Re: Application to Vary Condition 2 (Approved Plans)

Original Permission: 2020/62/92385/E – Erection of Warehouse

Site: HB Food Services, Vulcan Works, Vulcan Road, Eightlands, Dewsbury, WF13 2NA

Drg No: P-05
Scale: 1:1000 @ A3
Date: OCT 2025

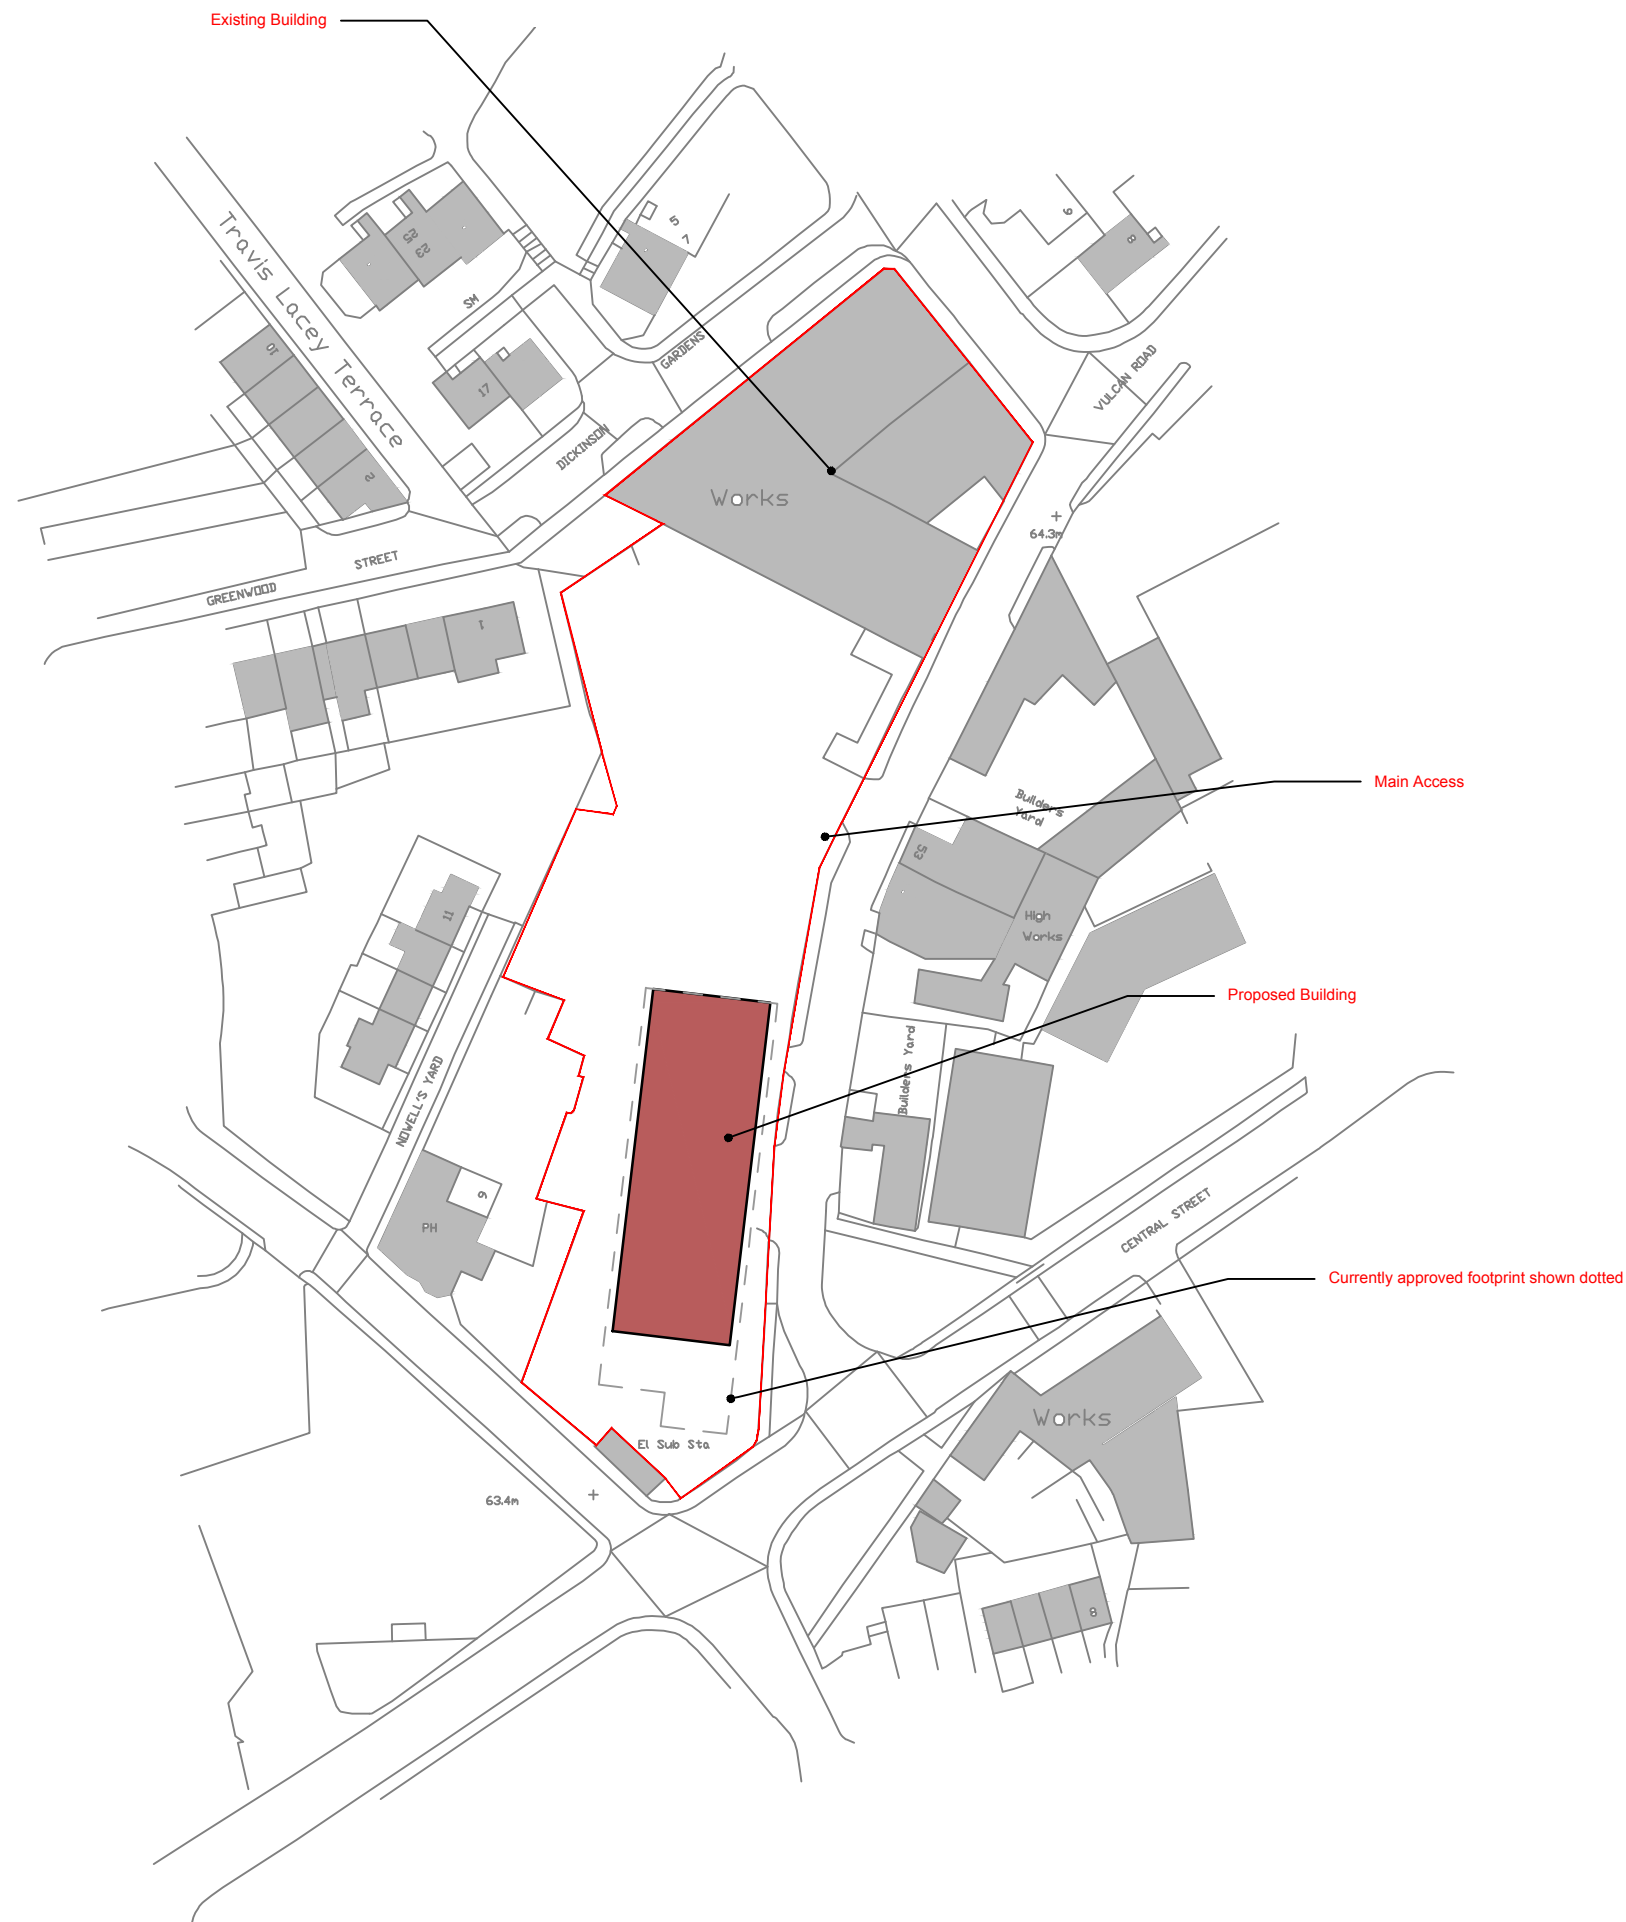
We are looking to amend the site block plan, the proposed elevations and the floor plan of the proposed building. The building remains an industrial structure with trapezoidal steel wall

Drg No: P-10
Scale: 1:200 @ A3
Date: Oct 2025

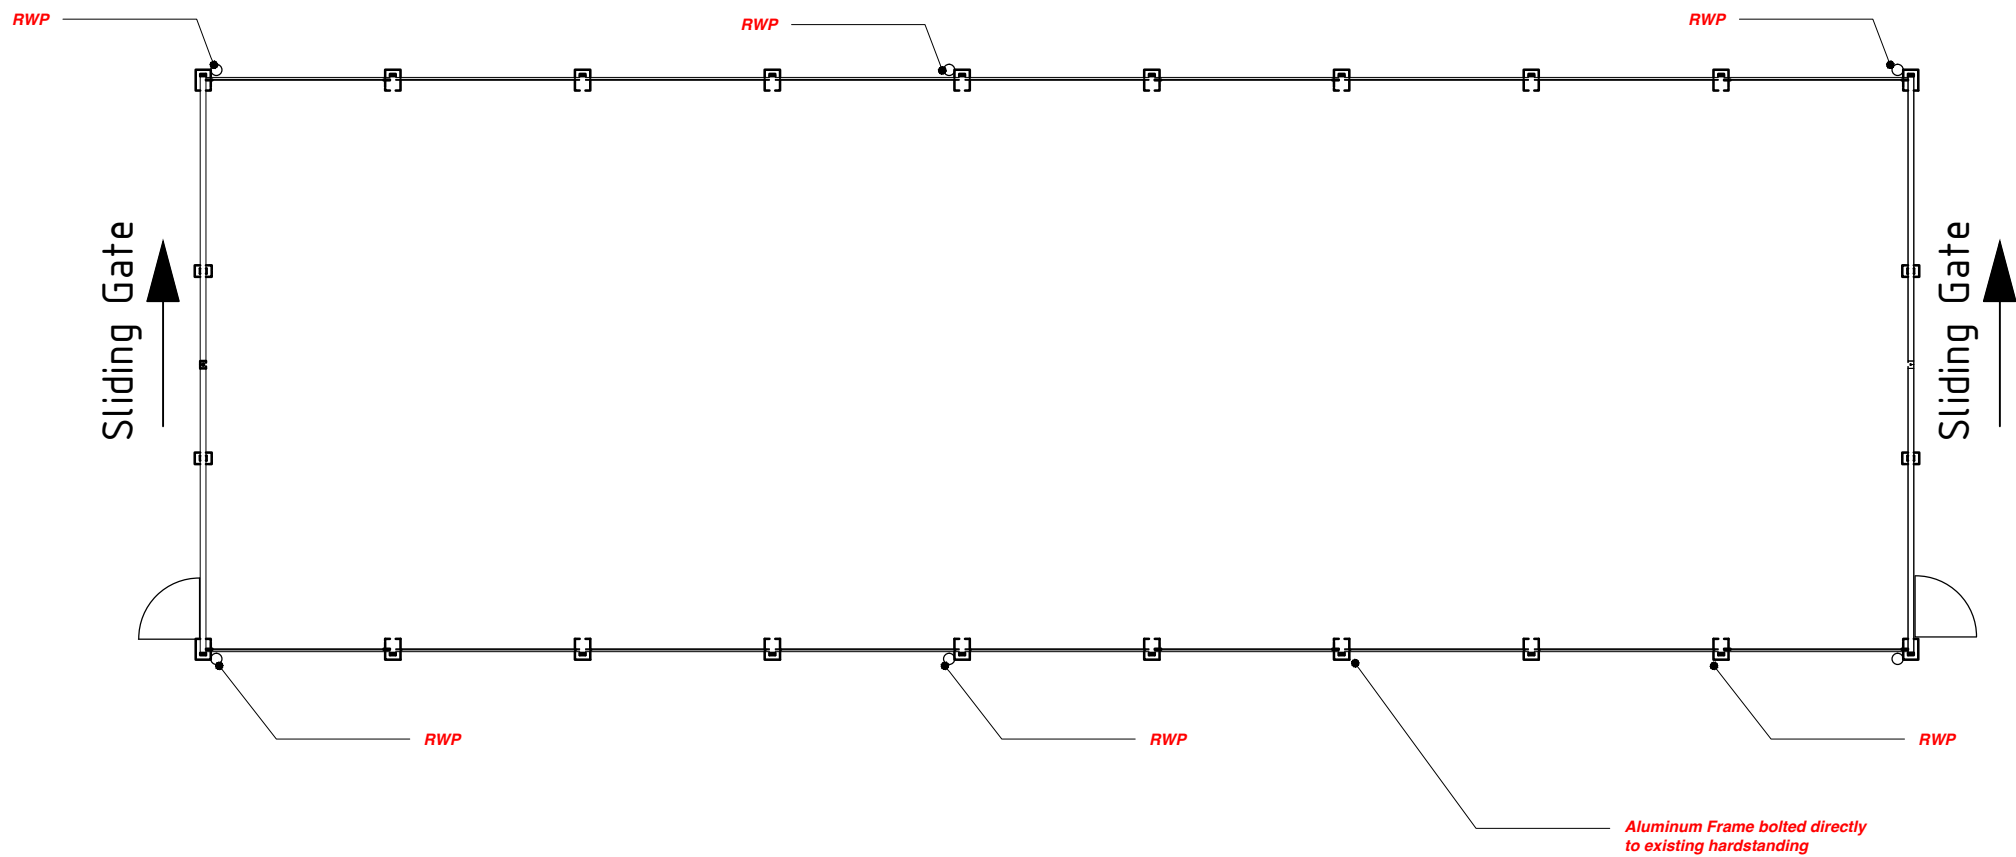
cladding, consistent with the general design, and overall appearance previously approved. No amendments are proposed to the site layout, access, drainage strategy, or the operational use of the site. The changes equate to a reduction in the floor area from 963 Sqm to 705 Sqm. The reduction in size does not materially effect the overall nature of the development but is deemed a significant enough change to warrant a section 73 application as opposed to a non material amendment.
